Yakama Nation Cultural Resource Program

September 13, 2021

Subject: Suncadia Phase 3 Div 17 Tumble Creek (LP-21-00002)

Site Development Plan Phase 3 Division 17 August 09, 2021

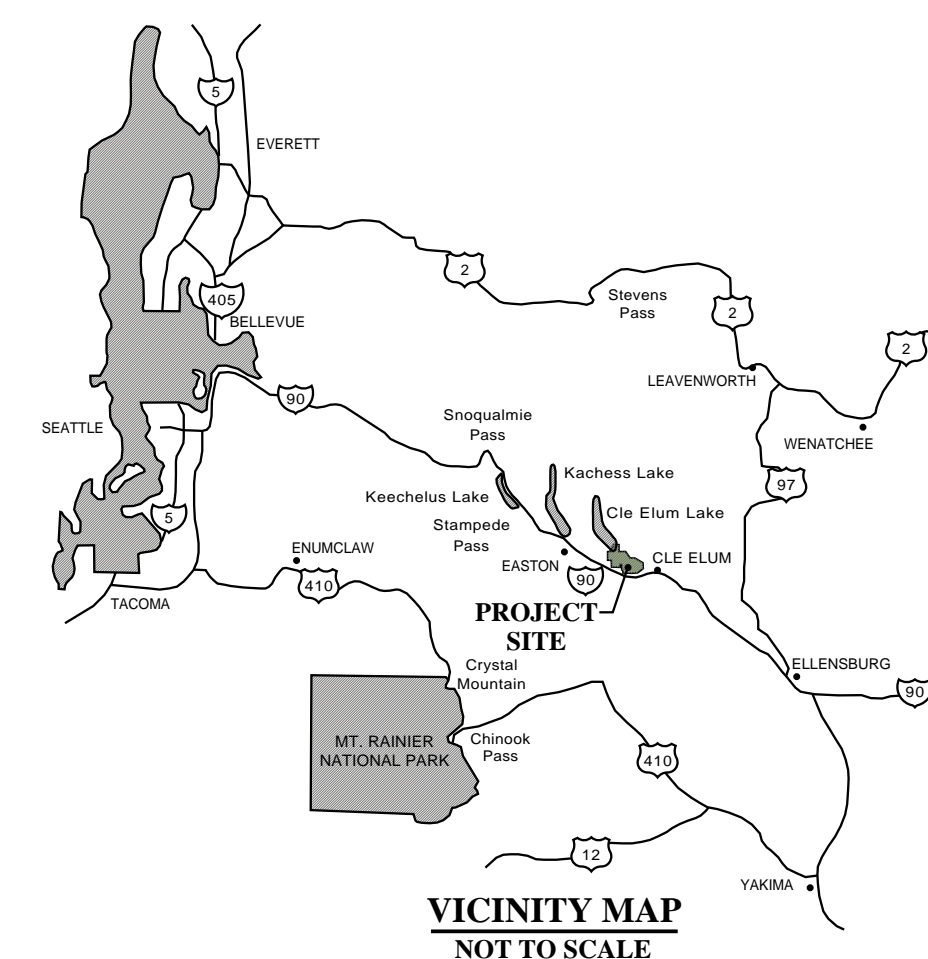
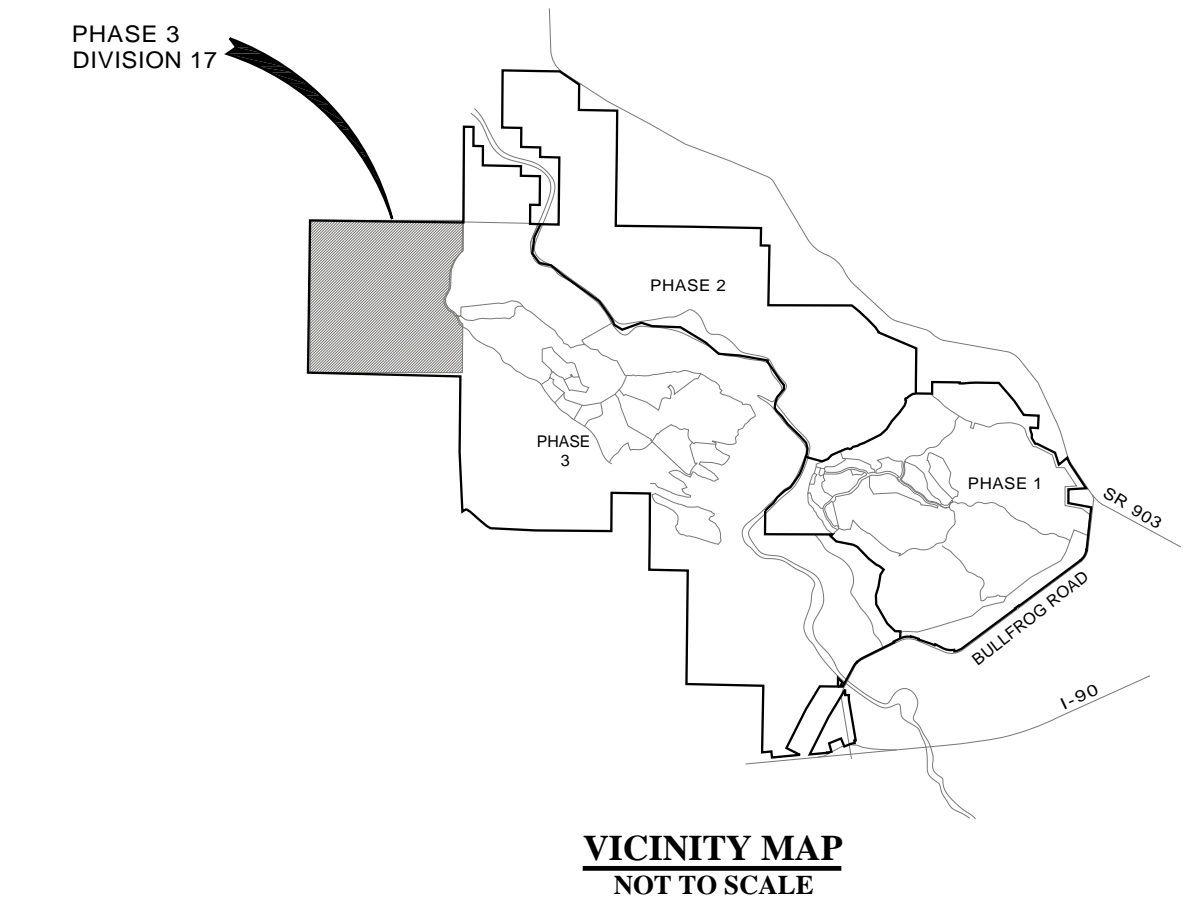
We are concerned the permit states an intended "reduction of the site buffer". The entirety of 45KT1363 is within a conservation area designated as 'managed open-space'. Archaeological sites are not renewable resources and protected under State Law. 45KT1363 was recommended eligible to the NRHP in 1998 and received concurrence by the Department of Archaeology and Historic Preservation on January 27, 1999. Any disturbances to this site is considered 'knowingly and willingly' – a violation of State Law RCW 27.53 with violators subject to criminal and civil penalties.

It is unclear from the application where the proposed housing phase is in relation to the managed open-space conservation areas. Please have additional information submitted to our program so we can better understand impacts.
